Application No: EP/91/20/HH
Site Address: 29 Vermont Drive East Preston BN16 1LG
Description of works: Single storey side extension and conversion of roofspace to habitable use to include a front and rear dormer.

Thank you for your internet representation made on 15th September 2020 which has been recorded as an objection with the comments as follows:

Revision	Date	Description
Client:		
Mr & Mrs J. Taylor, 29 Vermont Drive, East Preston.		
Project:		
Side Extension		
Drawing Title:		
Suggested Roof Room - SECTION		
Scale:	Date:	Drawn By:
1:100	15/07/2020	BE
Drawing Number:	Revision:	
1385/007	-

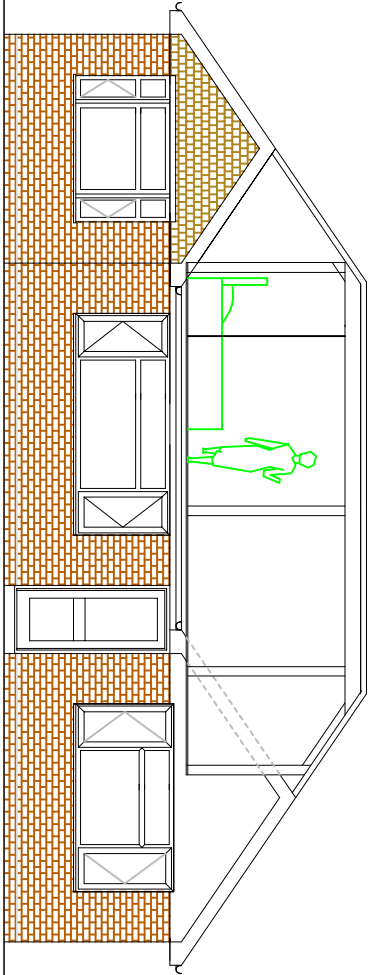
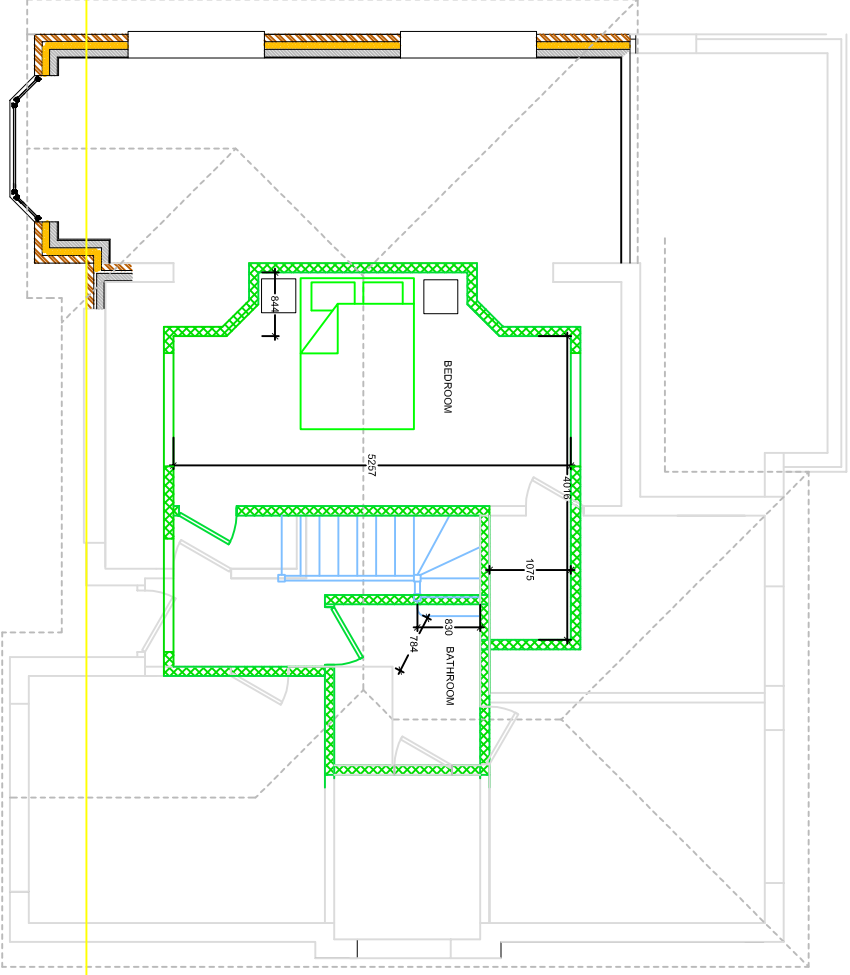
The East Preston Village Design Statement says dormers should be subservient to the roof and the committee felt this proposal was contrary to that as the top of the dormer is only just below the ridge of the roof.
